Proposed Residential
Development at Howth Road,
Dublin 3

Stage 1 Road Safety Audit

Document Ref: P21-018-RSA-PD-RP-001

CLIENT GLL PRS HOLDCO LIMITED	
PROJECT TITLE DEVELOPMENT AT HOWTH ROAD	BM PROJECT No. 19196
MODEL REFERENCE	MODEL REV. SUITABILITY
DRAWING TITLE PROPOSED SITE LAYOUT	
DRAWING No. HOW-BMD-00-ZZ-DR-C1000	ISSUE P7

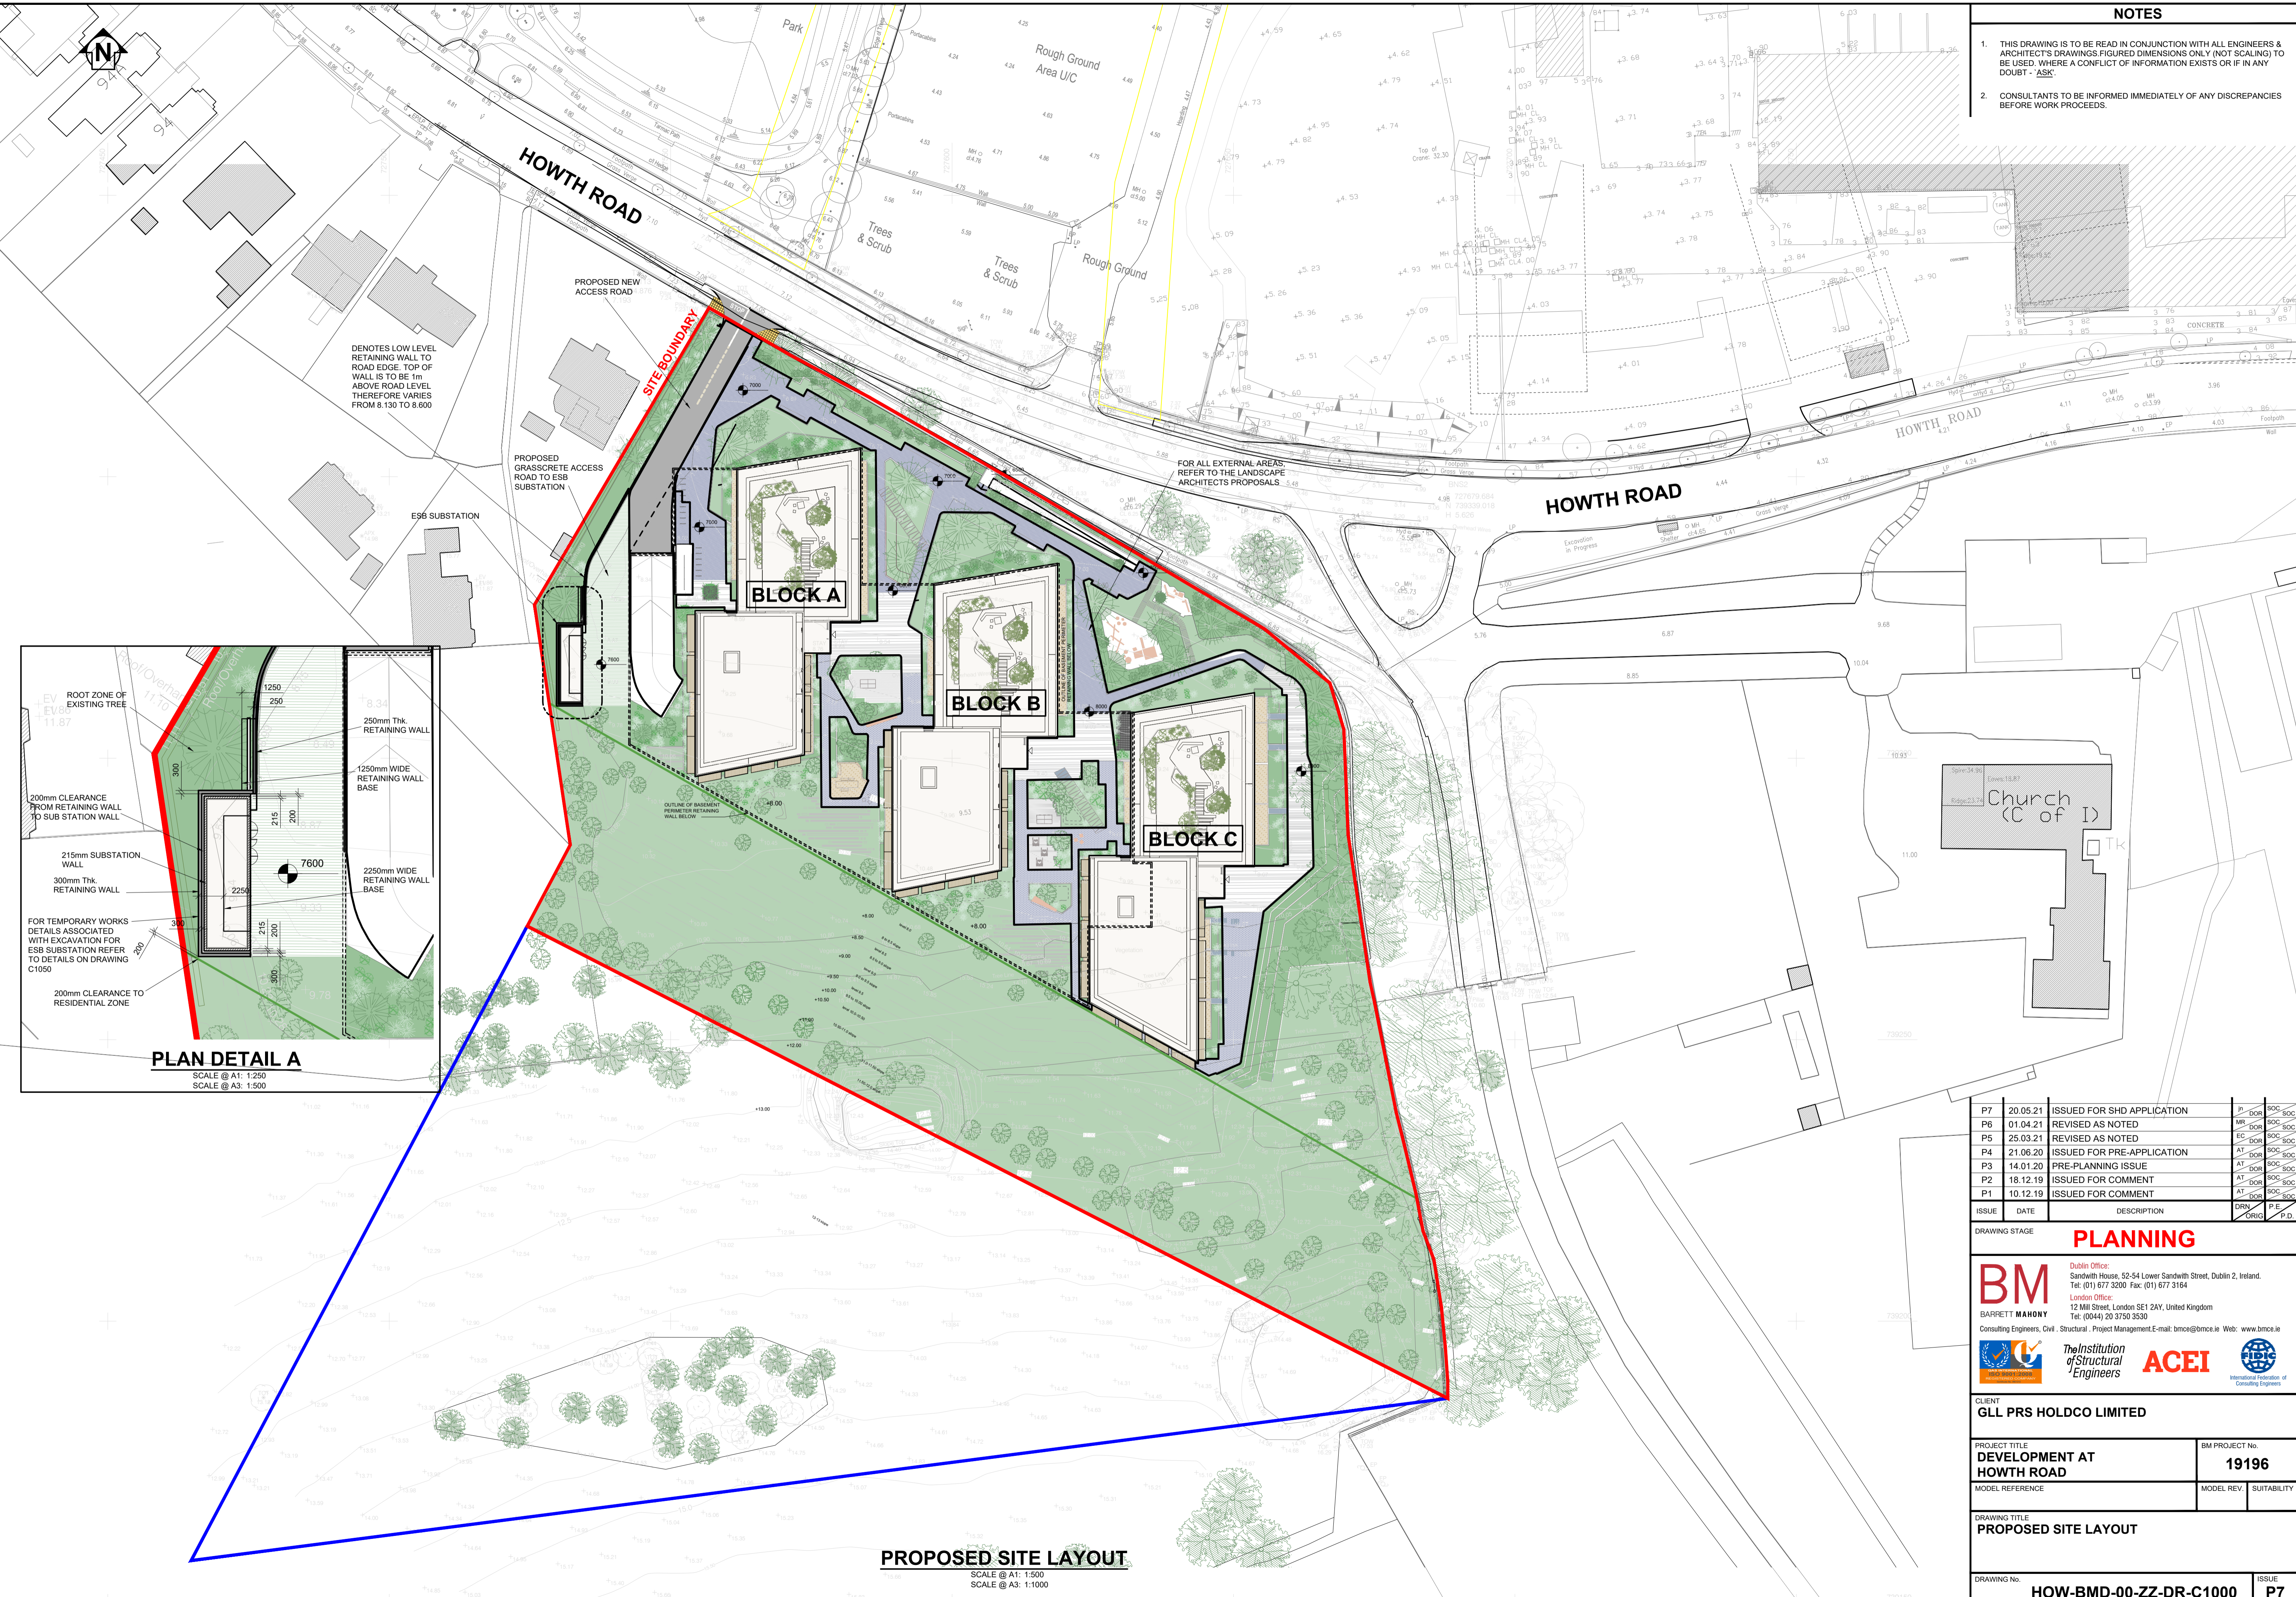
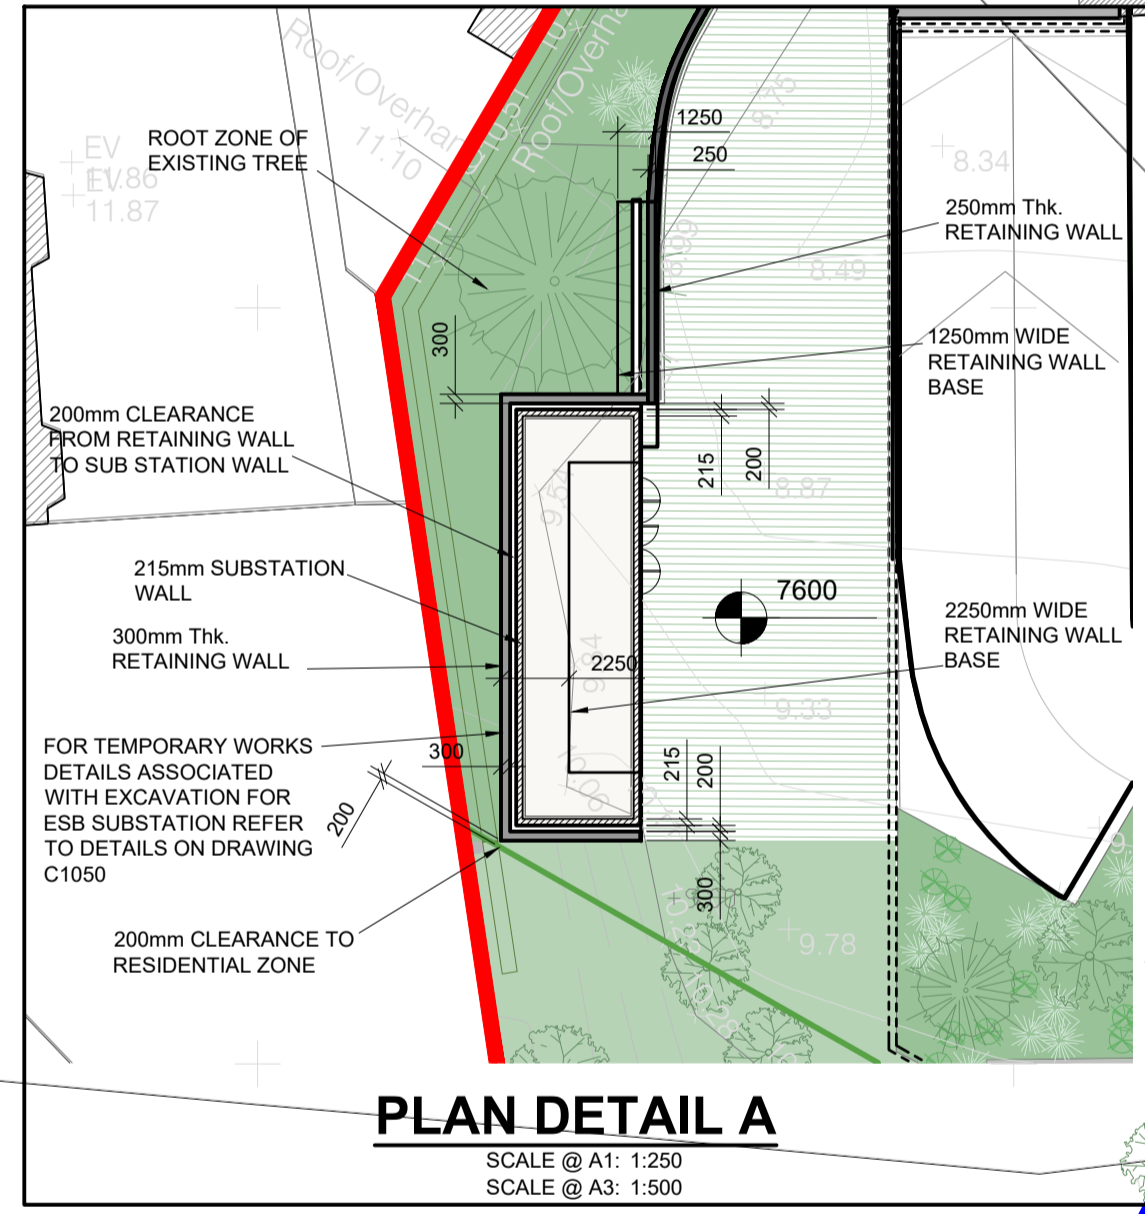
Location: Drawing HOW-BMD-00-ZZ-DR-C1000 (Rev. P4)

Summary: The tactile paving indicated at the uncontrolled crossing of the development access is not of the required depth across the full width of the crossing.

Tactile paving has been indicated on both sides of the access to the proposed development. The depth of the tactile paving, however, is not sufficient across the full width of the crossing for an inline crossing.

This could lead to a visually impaired pedestrian stepping over the tactile paving, where it is of insufficient depth, and inadvertently entering the carriageway without due care and attention where they are at an increased risk of being struck by a vehicle.

3.4 Problem

Location: Drawing HOW-BMD-00-ZZ-DR-C1000 (Rev. P4)

Summary: Pedestrians, particularly young children, may climb the embankment to the rear of the development where there is a risk of falls from a height and serious injuries.

An embankment is indicated to the rear of the apartment blocks within the proposed development which is indicated as rising in increments of 0.5m, with level surfaces between each rise, with a total rise of 4m. The Audit Team are concerned that pedestrians, particularly young children, may climb on the embankment where there is a subsequent risk of falls from height and the potential for serious injury.

Ensure the tactile paving is a minimum of 1.2m deep across the full width of the crossing.

Measures (i.e. vegetation, landscaping, fencing etc) should be provided at the base of the embankment to deter climbing.

DRAWING No. **HOW-BMD-00-ZZ-DR-C1001** ISSUE **P5**

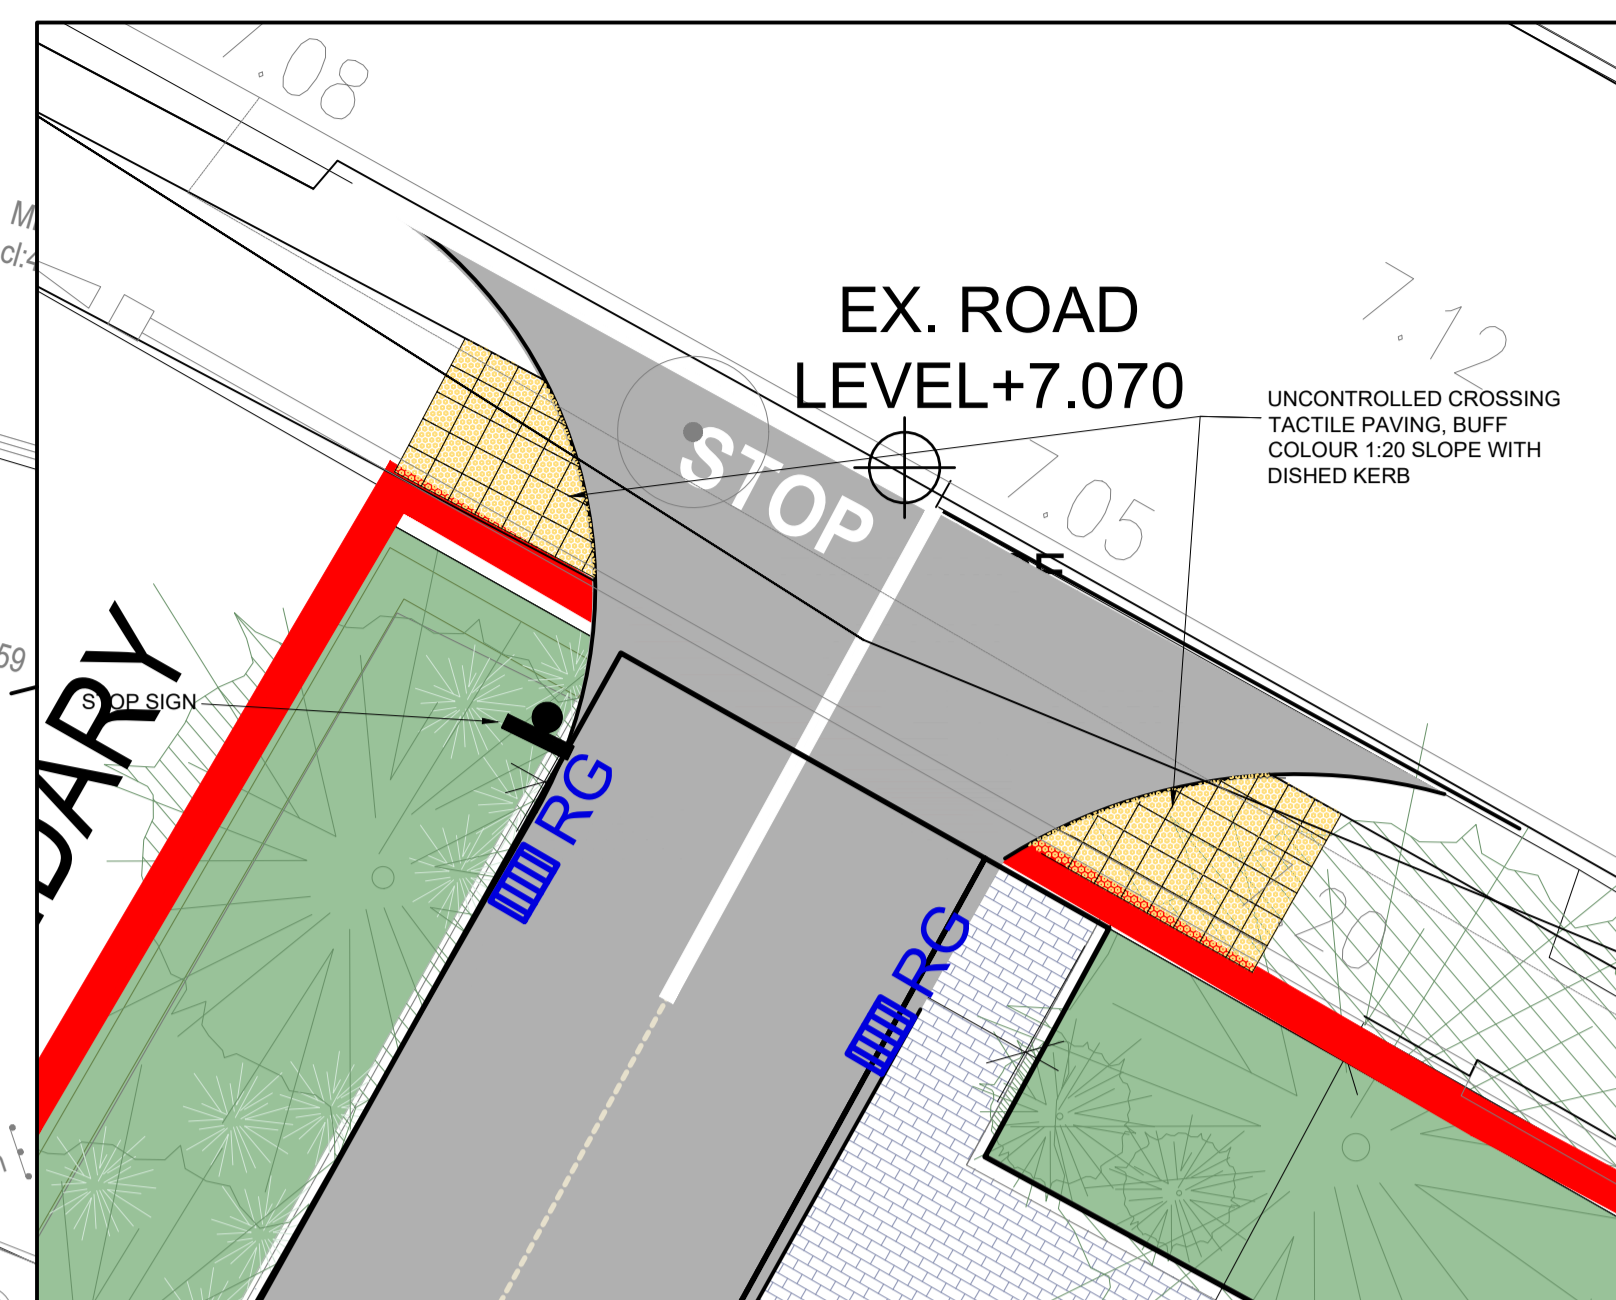
Location: Drawing HOW-BMD-00-ZZ-DR-C1001 (Rev. P4)

Summary: Sudden change in the horizontal alignment of the access and the narrowing of the carriageway at the top of the ramp may lead to poor lane discipline and kerb strikes.

The access road within the proposed development leading to the access ramp to the basement carpark includes sudden changes of direction in the horizontal alignment and appears to widen at the top of the ramp, which coincides with the location of these changes in direction.

A combination of the narrowing cross section and sudden changes in direction may lead to drivers being unable to sufficiently discern the edge of carriageway and thus the narrowing, particularly during the hours of darkness resulting in the potential for kerb strikes and material damage collisions.

Ensure the wider carriageway gradually tapers at the narrowing and that the edge of carriageway is sufficiently visible on the approach to, and departure from, the basement carpark access ramp.

Also, as the design progresses, ensure the access road is sufficiently lit.
